RE: **3300 2nd St NW**
Grading and Drainage Plan
Engineer's Stamp Date: 5/2/18
Hydrology File: G14D091

Based on the information provided in your submittal received on 5/8/18, the Grading Plan cannot be approved for Paving Permit until the following are addressed:

PROJECT NO.	R307382.02
DESIGNED BY:	GM
DRAWN BY:	VKL
CHECKED BY:	SE
DATE:	MAR. 28, 2018
DPW CHK:	-
SHEET:	
C102

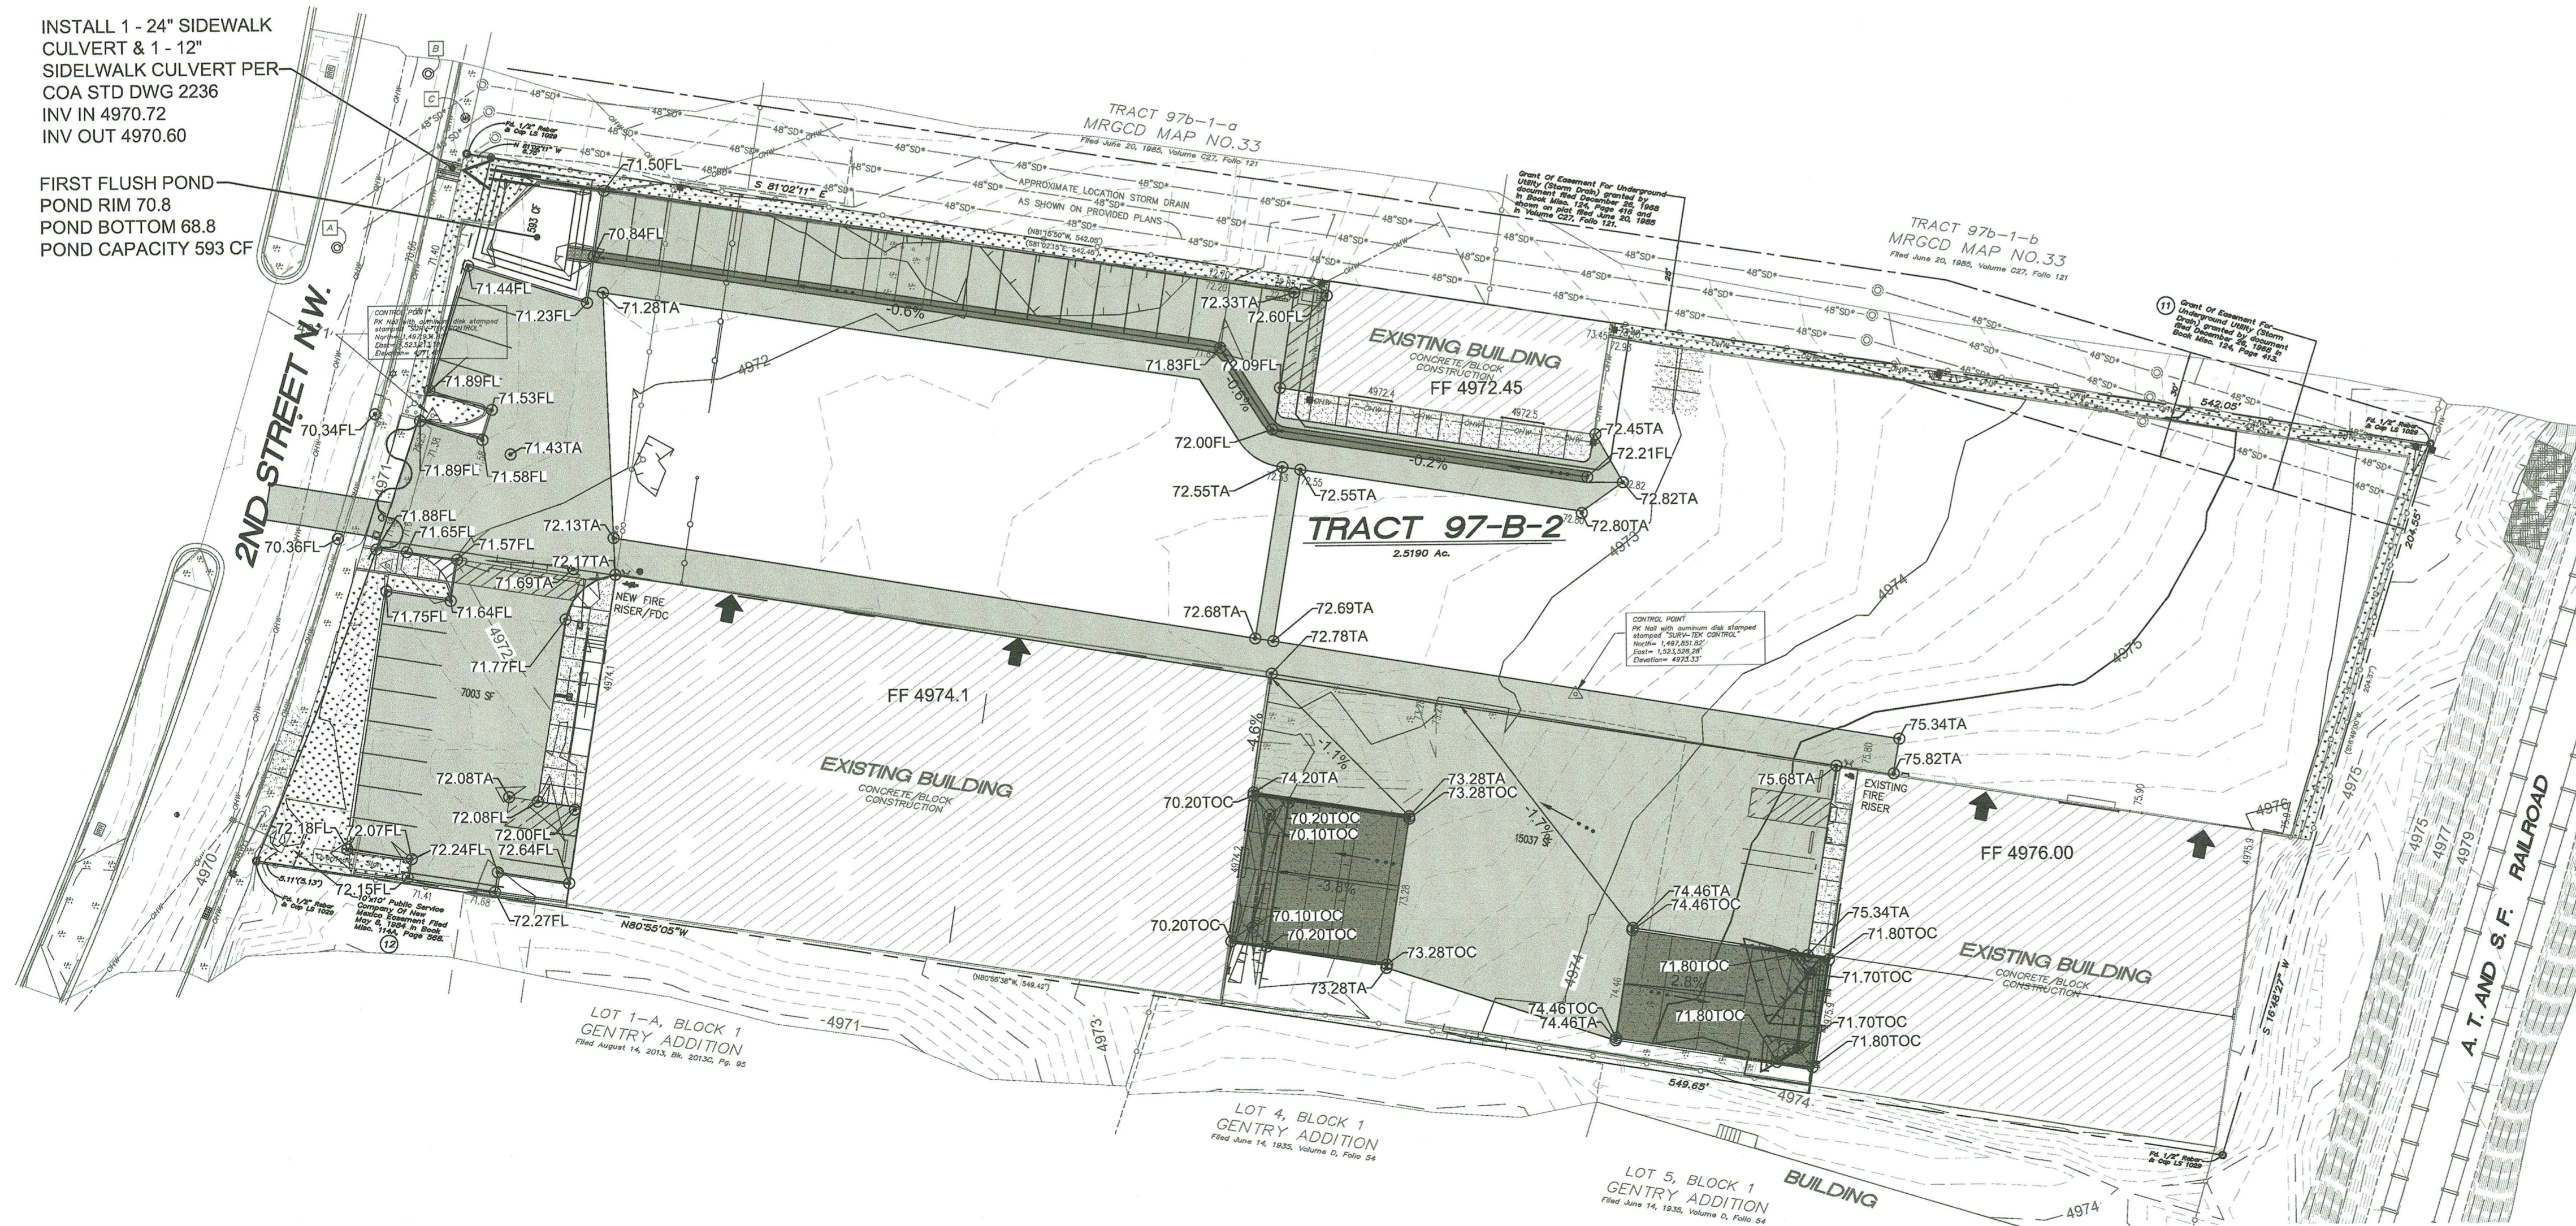
1. Provide spot elevations and proposed contours.
2. Provide benchmark and elevation data.
3. What is the area of new pavement? The first flush requirement needs to be calculated and shown on plans; use the redevelopment requirement of 0.26"/12 x new impervious. The first flush pond needs to be sized for this volume.

4. The waterblock needs to be sufficient to convey site flow to the pond. The sidewalk culvert, not the drive entrance should be the discharge point for this site.

6. The sidewalk culvert needs to be built per 2236 and requires an SO-19 permit. Include the latest SO-19 notes on the grading plan (attached).
7. Provide supporting calculations to ensure the sidewalk culvert is sized for the 100-yr flow.
